Your ref:
Our ref: 23/00683/F
Please ask for: Miss Joanne Wren
Direct dial: 01553 616233
E-mail: borough.planning@west-norfolk.gov.uk

Details: **Subdivision of curtilage of dwelling and annexe to create two separate dwellings at Castle Dene Castle Road Wormegay KINGS LYNN Norfolk**

Location Plan

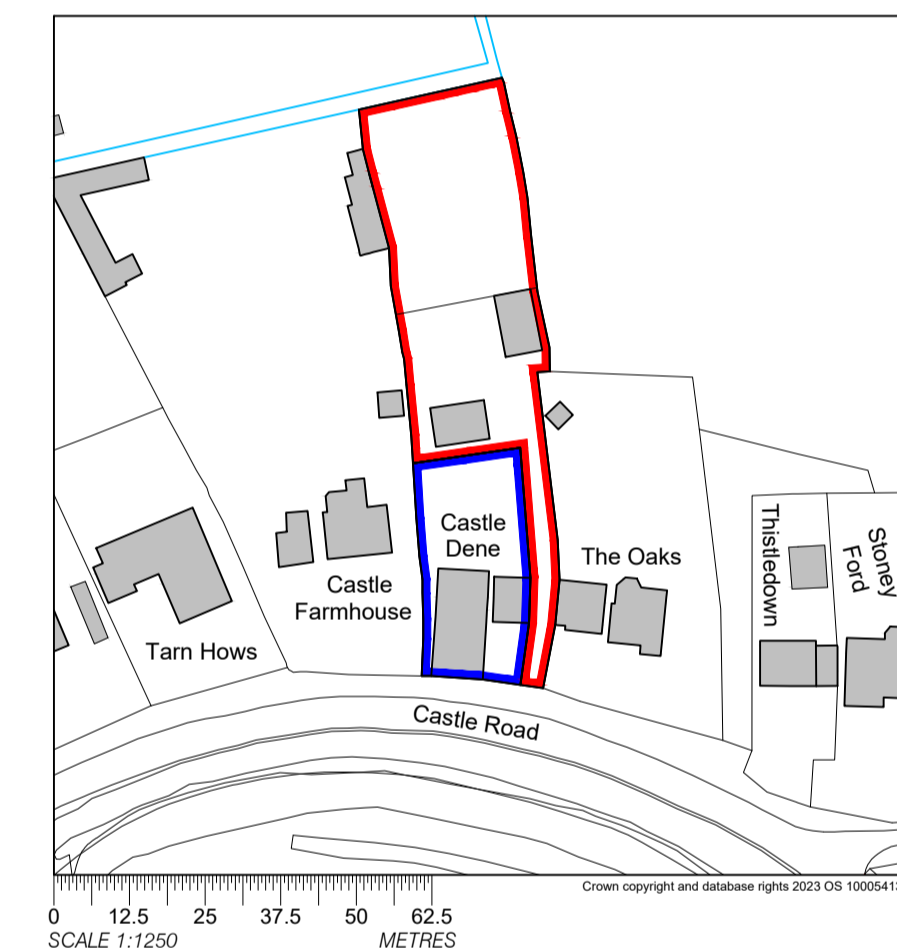
4. Please amend the red line on your location plan, this should edge the whole site so that both the current red and blue land is edged entirely in red.
5. As the property lies within an area at risk to flooding, please complete the simplified Matrix and return it. The Matrix can be found at https://www.west-norfolk.gov.uk/info/20173/information_for_planning_agents/231/flood_risk_information
